DECISION DELEGATED TO DEVELOPMENT MANAGER

Application No: H16-0202-19 **Applicant:** Mr & Mrs Pilgrim
Proposal: Proposed 2 storey side extension
Location: 74 Pennygate Spalding
Terminal Date: 22nd April 2019

Proposed Plans

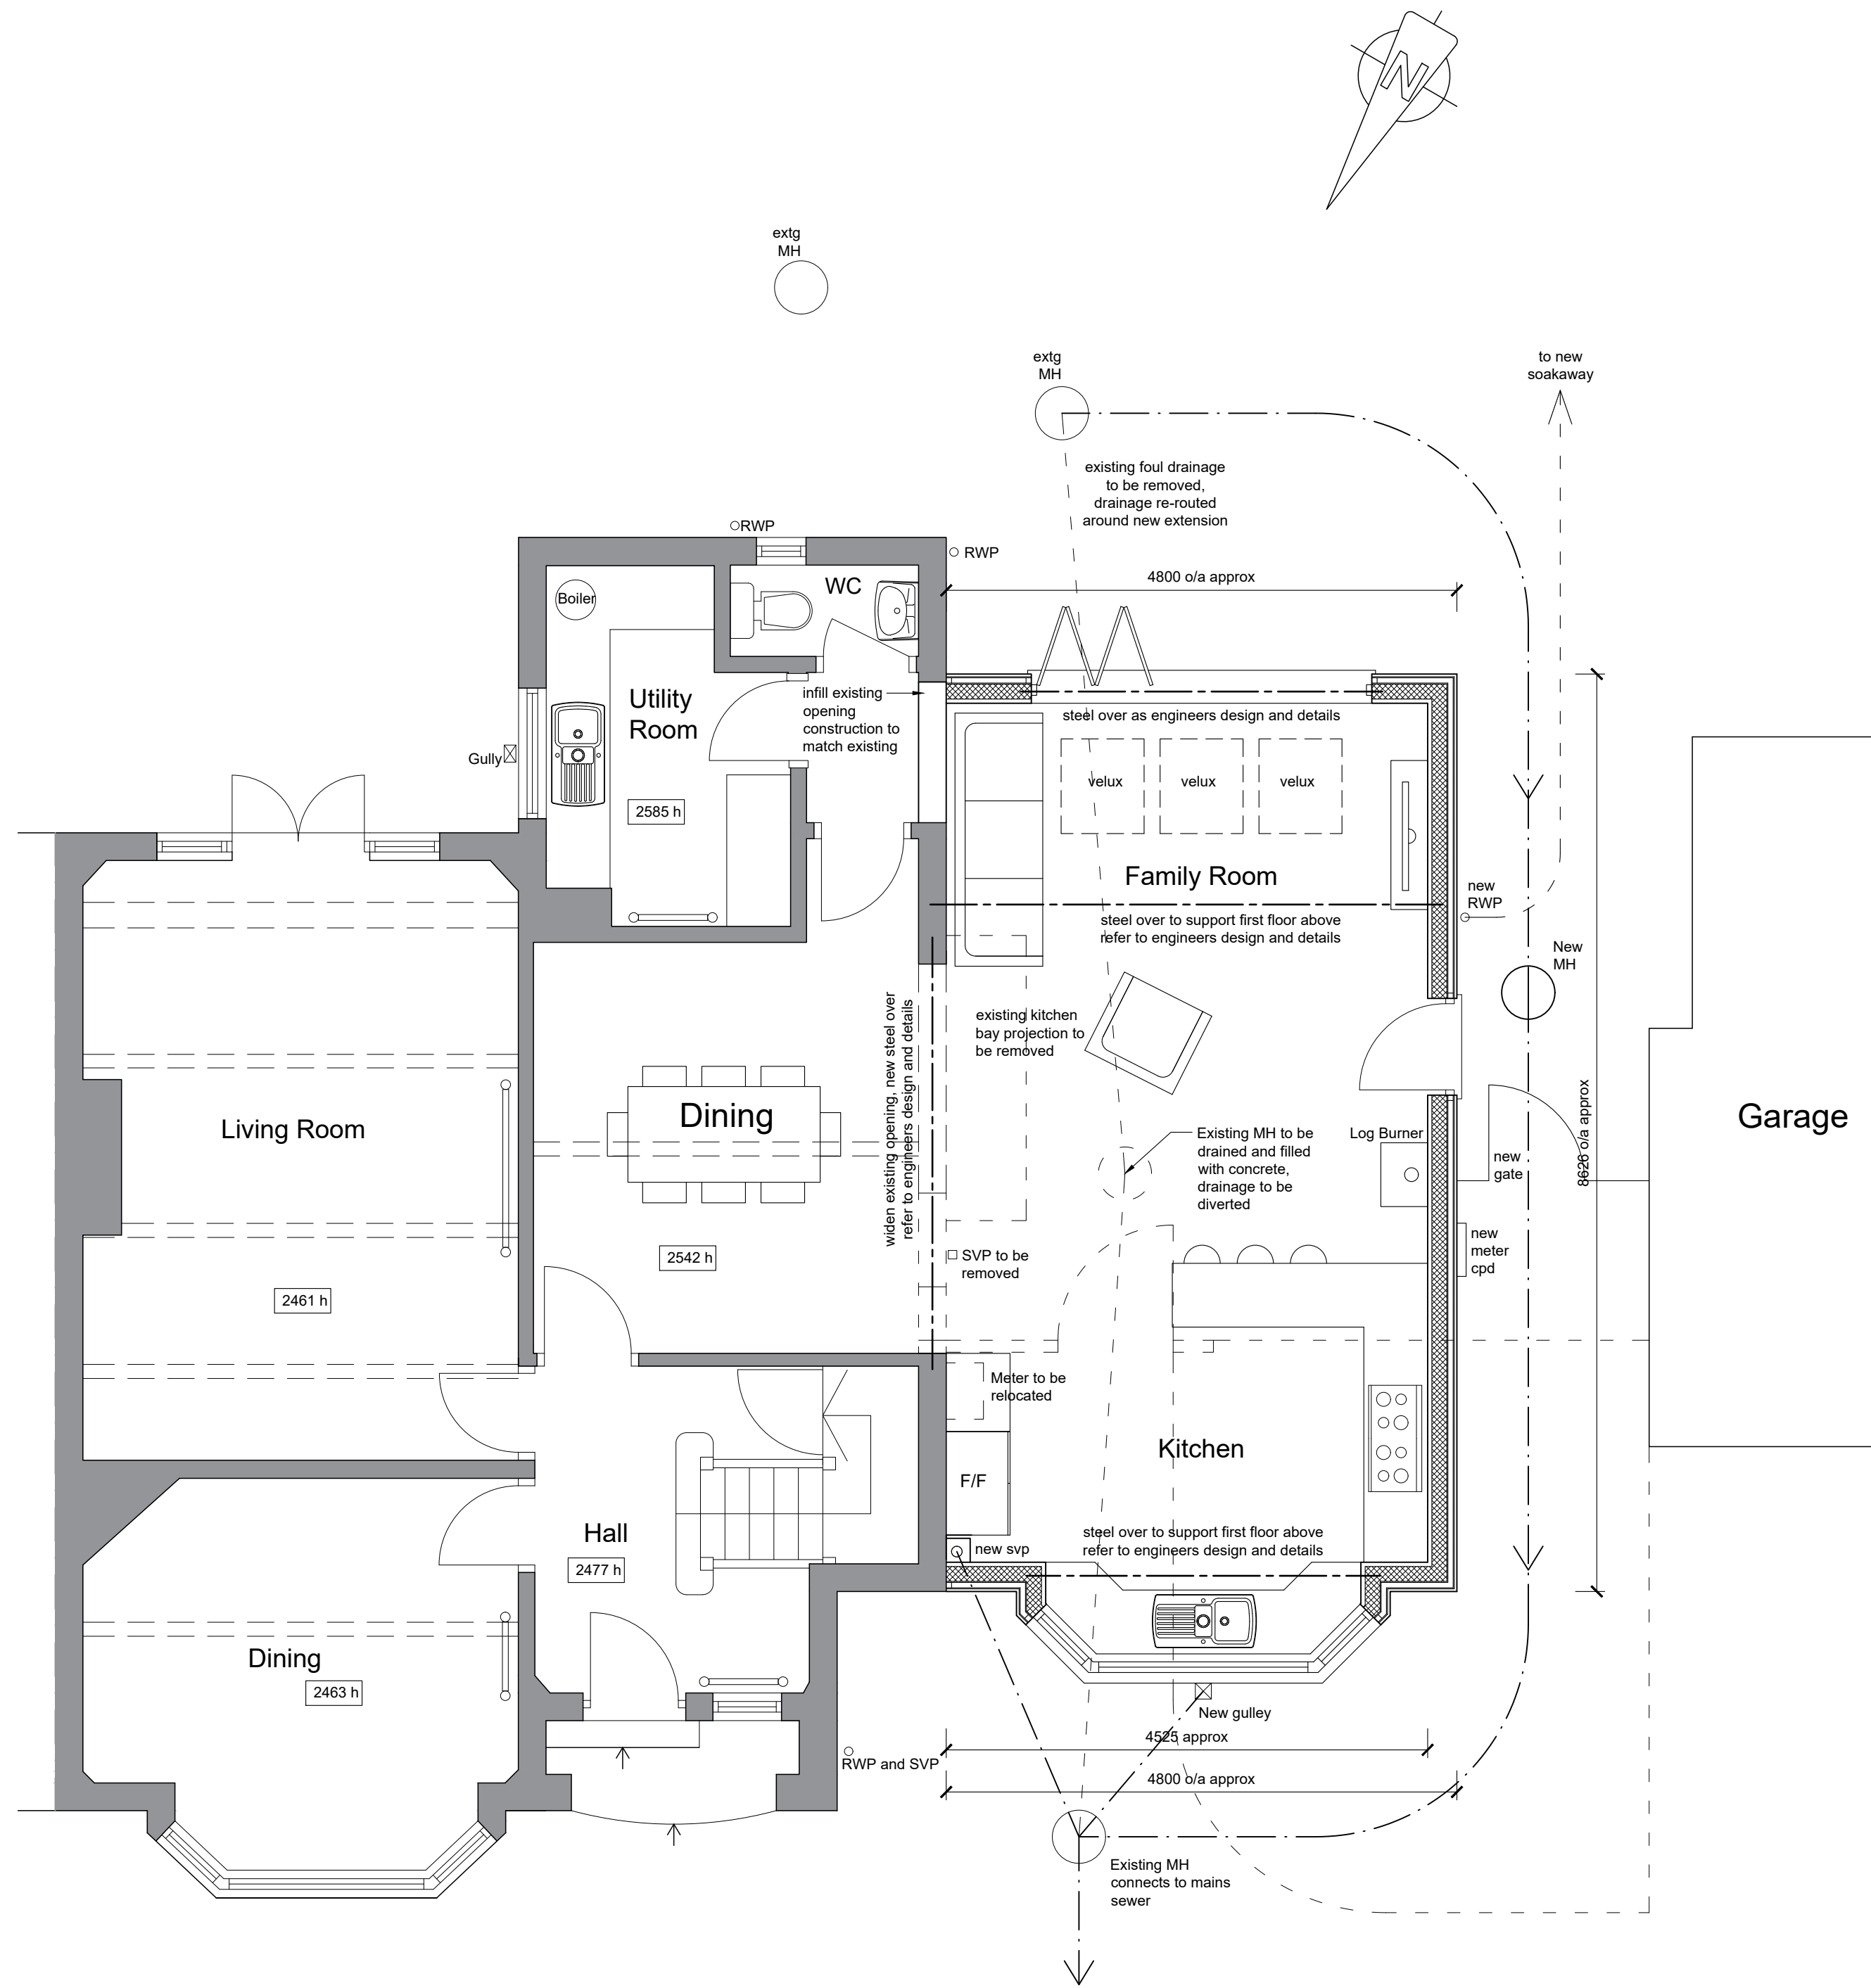
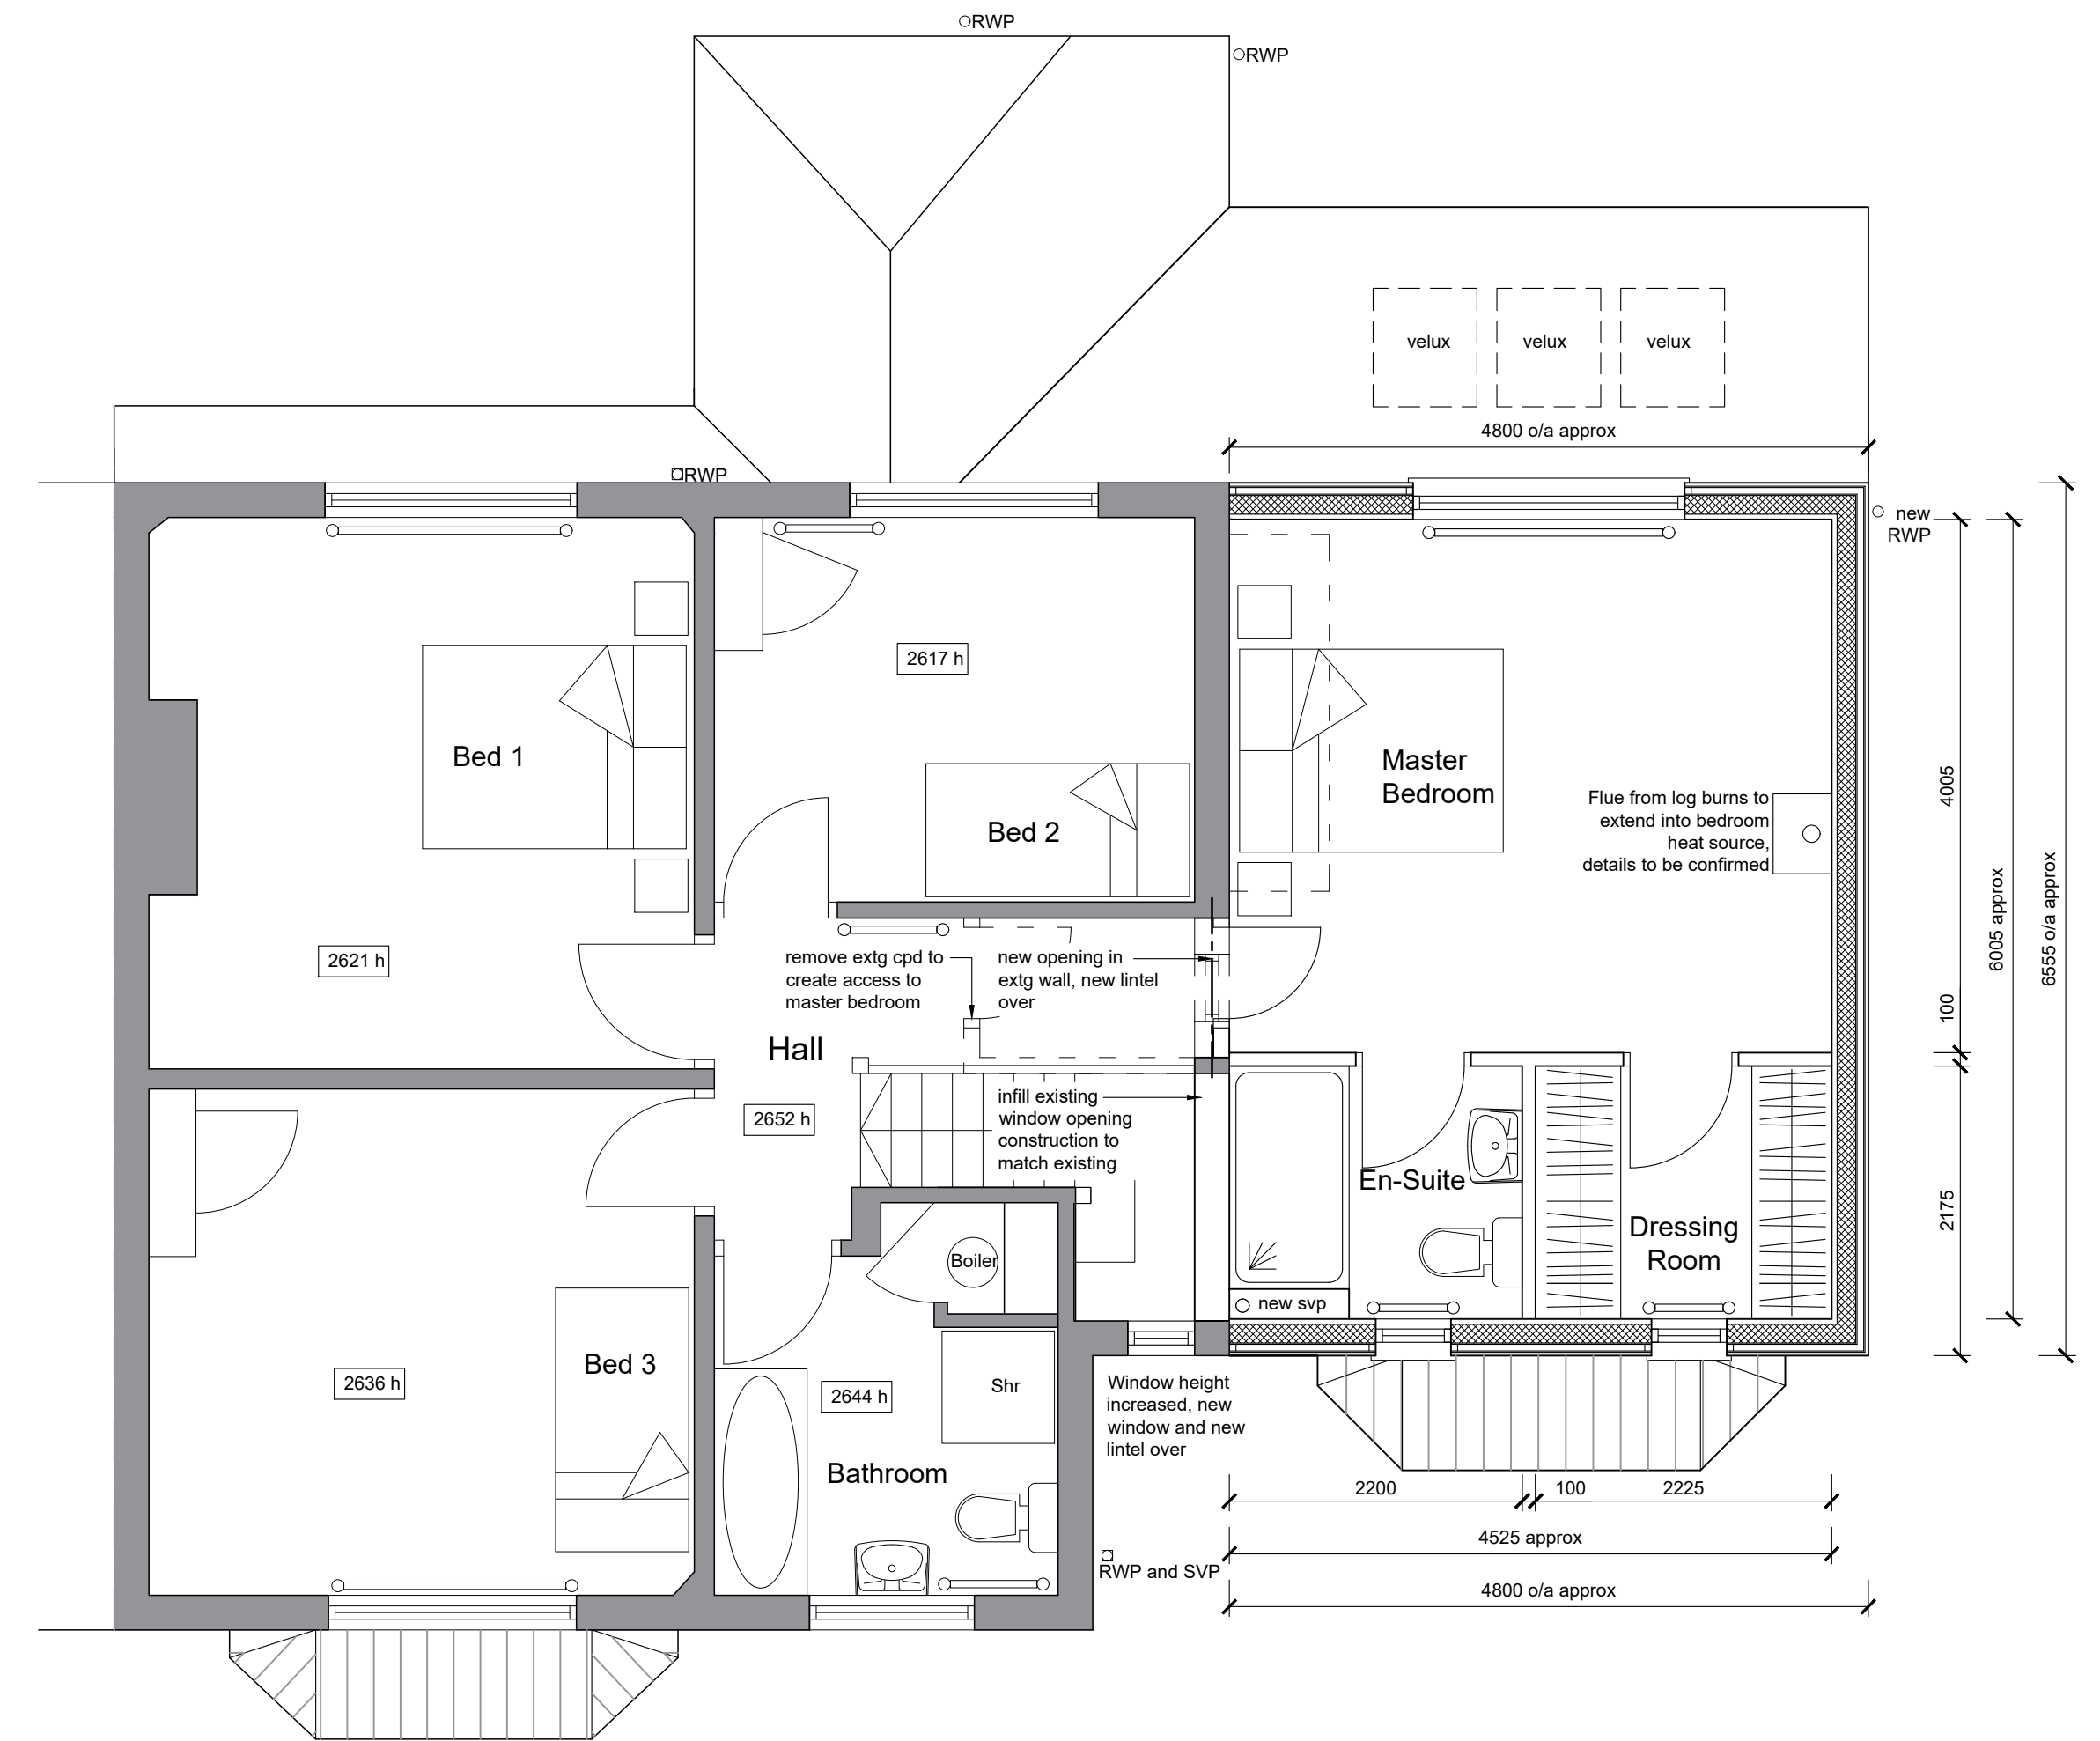
In view of the adjacent buildings and their position in relation to the development, no windows on the first floor would create any overlooking impact to the neighbouring properties. A separation distance of approximately 1.81 metres is provided between the extension and adjacent garage thus access between the rear and front part of the site would be granted. There would be further distance with the boundary lines and opposing elevation of adjacent dwellings. In conclusion, no harm upon the residential amenity standard would occur should the development was built.

Proposed Elevations

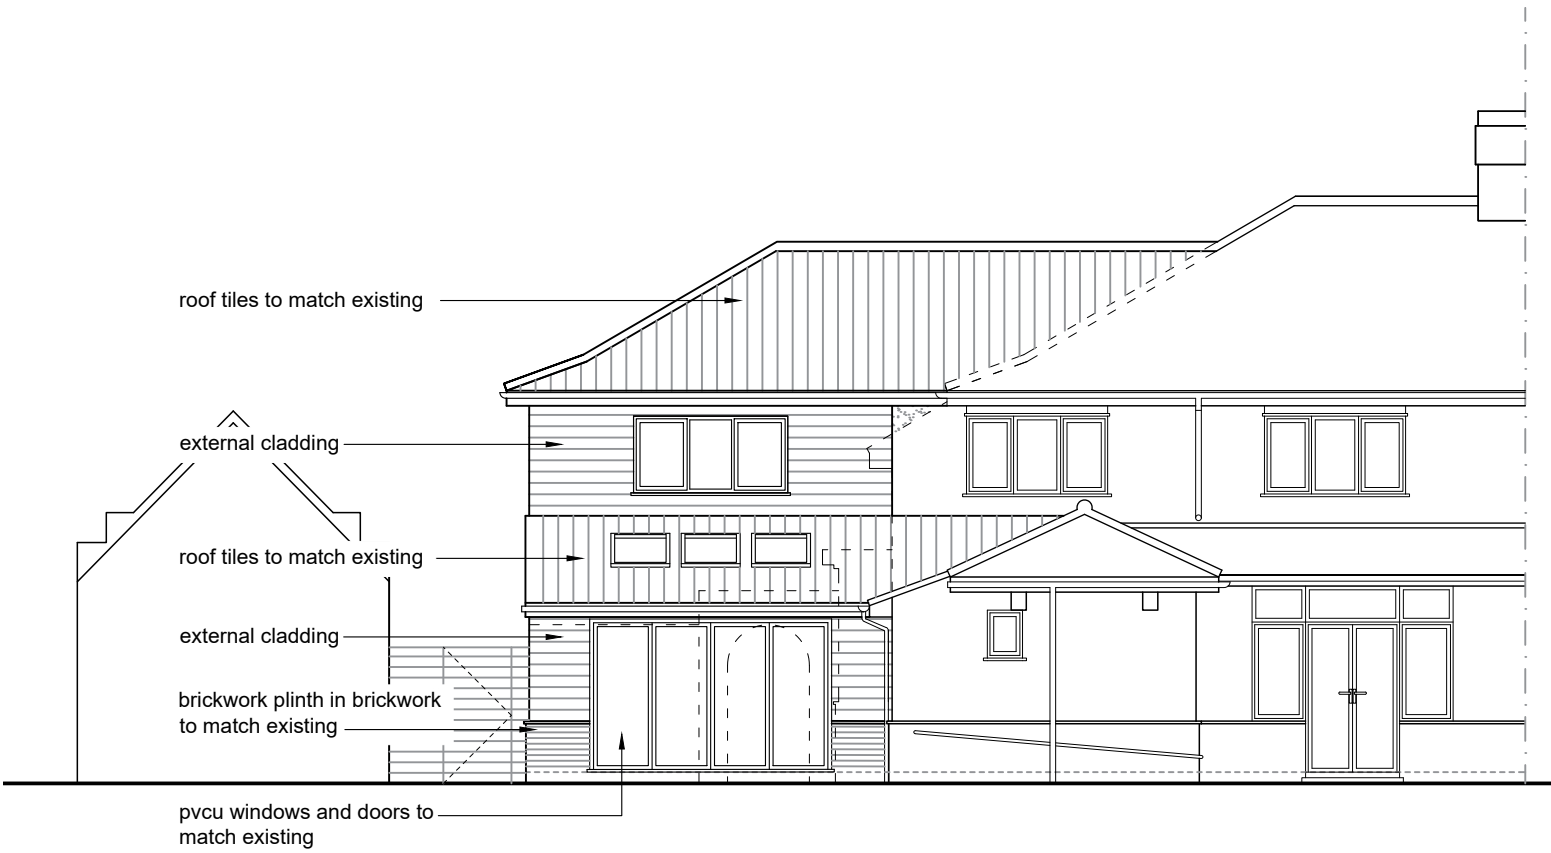
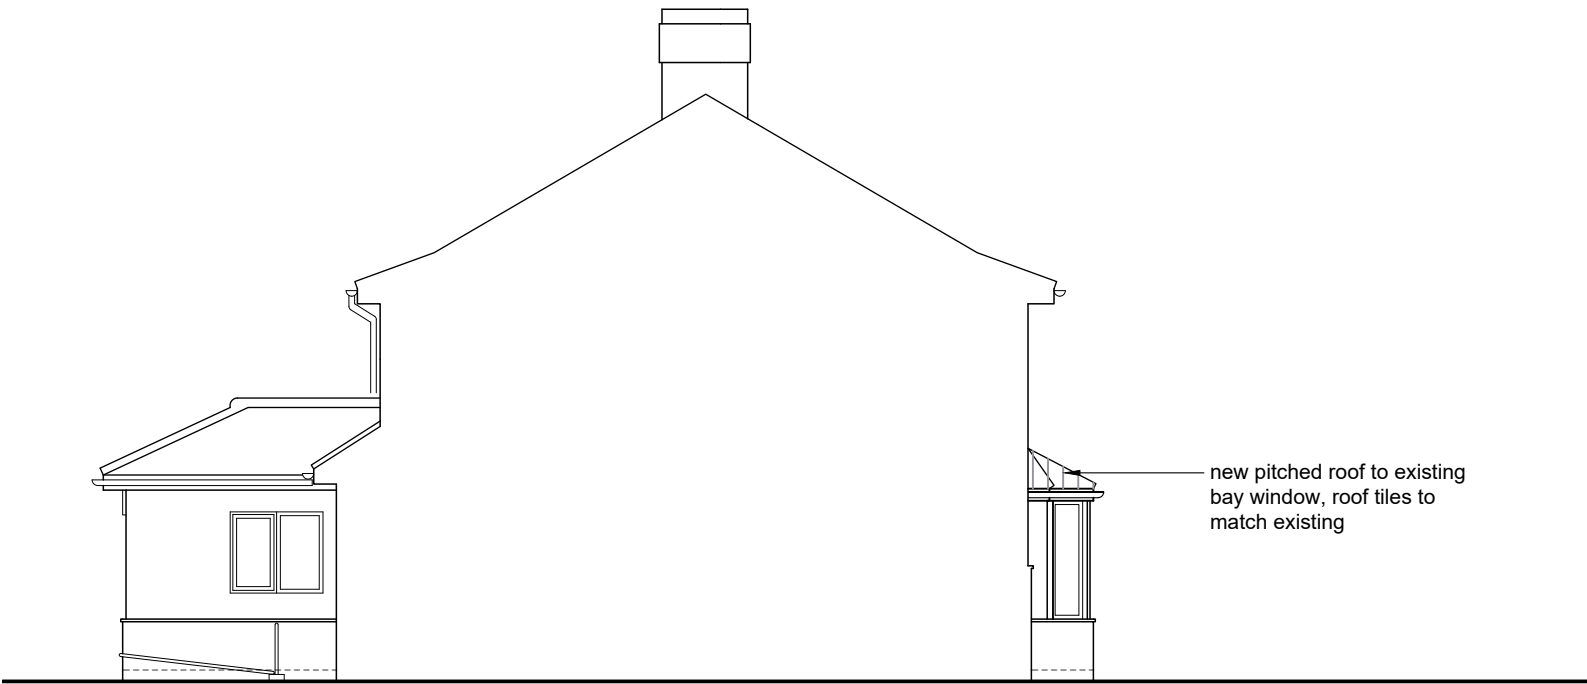
The property is a two-storey traditional semi-detached house. The proposed extension would protrude 4.80 metres from the western side elevation. It would measure 8.62 metres in depth and 7.20 metres in maximum apex height. The eaves would be 5 metres high. Having regard to the dimensions of the dwelling, the intended development would be commensurate to the host property in terms of scale, massing and bulking.

The extension would be aligned with the rear elevation of the house which represents that the bulk would be visibly set back from the principal elevation given the proposed depth of the extension. Accordingly, the roof apex and ridgeline of the extension would be just below the highest point and ridge of the main roof. Such features would deliver an external layout in subservience with the main property. A hip roof and bay window would mirror those currently in the house which would provide coherency to the form of development in relation to the dwellinghouse.

When it comes to the external materials, the house currently has brickwork plinth and white render on the external wall. Matching brickwork would be applied on the plinth of the extension although the remainder of the elevation would have cladding instead of matching render finish. The presence of cladding is well regarded in order to upgrade the appearance of the traditional house. However, it must be ensure that the resulting appearance would relate well with the host property and adjacent buildings. Therefore, a planning condition is recommended to obtain further details of the proposed cladding and resist any detrimental impact upon the visual amenity. White UPVC would be used for the fenestration. Gutters and downpipes would be in black colour. This clearly match the appearance of the existing in the dwellinghouse.
